Appeal Decision

Appeal Ref: APP/R5510/D/20/3254495 103 Lime Grove, Ruislip HA4 8RW

- The appeal is made under section 78 of the Town and Country Planning Act 1990 against a refusal to grant planning permission.
 - The appeal is made by Mr Mitchell Comer against the decision of the Council of the London Borough of Hillingdon.
 - The application Ref 75001/APP/2020/257, dated 27 January 2020, was refused by notice dated 26 March 2020.
 - The development proposed is described as two storey side extension, part conversion of garage and conversion of roofspace to habitable use to include a rear dormer (resubmission).
-

Drawing Title:
103 - Proposed Floor Plans & Elevations REV A

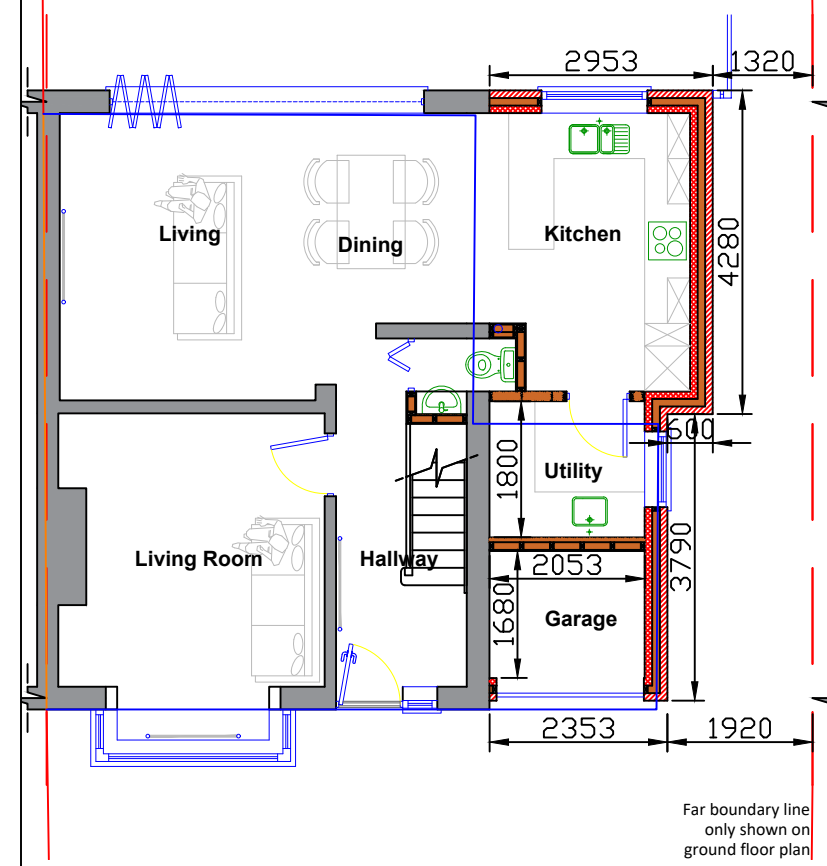
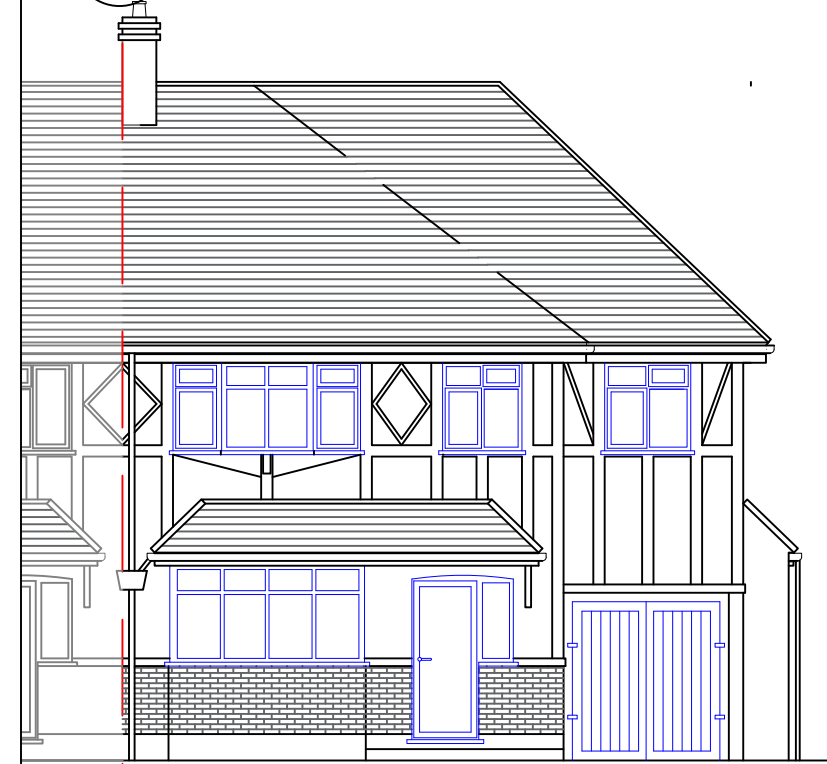
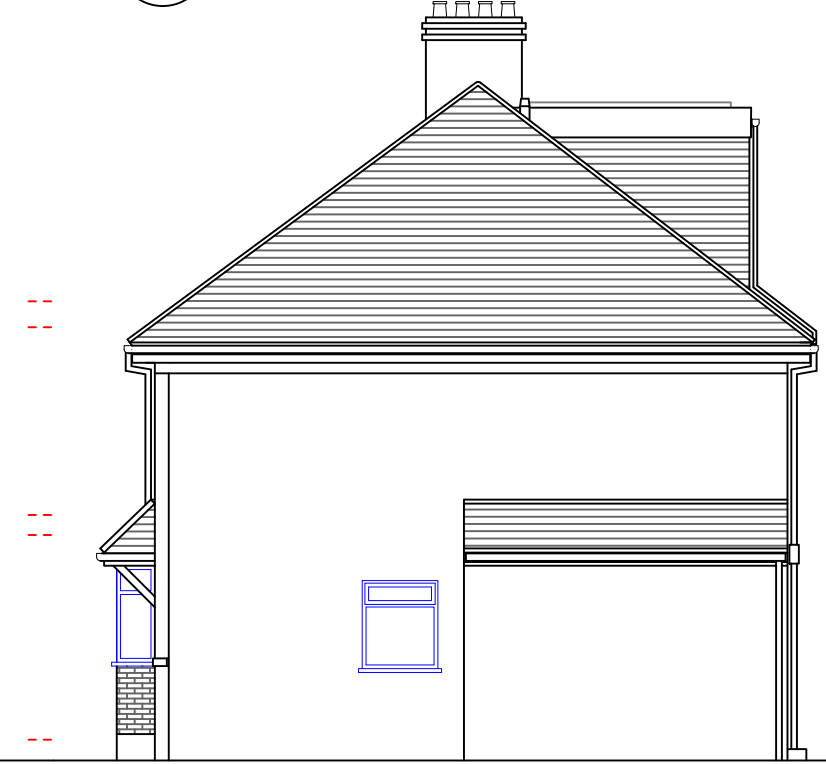
8. The proposed two storey side extension would extend the massing of the roof in a similar way to the extended roof at the other side terrace property, No 99. The side extension would be limited in width and would extend no further than the existing single storey projection, save for a minor single storey element towards the rear. Although the extension would not be set back significantly from the existing frontage, this would mirror the extension to No 99 and would thus not result in harm to the symmetry of the terrace. Whilst there would be a slight change in the angle of the roof pitch, this would not be visually obvious, and would be to the degree that would result in harm to the host property, or the terrace of which it forms part.

9. Although it is submitted that the distance between the side boundary and the side extension would be less than the 1 metre desired by Policy DMHD 1, Part C (iv) of the London Borough of Hillingdon Local Plan Part 2 Development Management Policies (2020)(DM), there would remain a visual gap between the extended host property and the single storey dwelling at No 105. The extension would not result in a cramped form of development upon the site. In this regard there would be no conflict with the purpose of this part of DM Policy DMHD 1 which seeks to maintain adequate visual separation and views between houses.

10. Whilst wider than 'two thirds the average width of the original roof' as set out in part E (i) of Policy DMHD 1 of the DM, the rear dormer would sit comfortably within the extended roof plane and would not appear dominant nor incongruous. The dormer would appear similarly sized to that of the adjoining neighbour, No 101, and would not appear out of keeping with the existing dwelling or wider terrace.
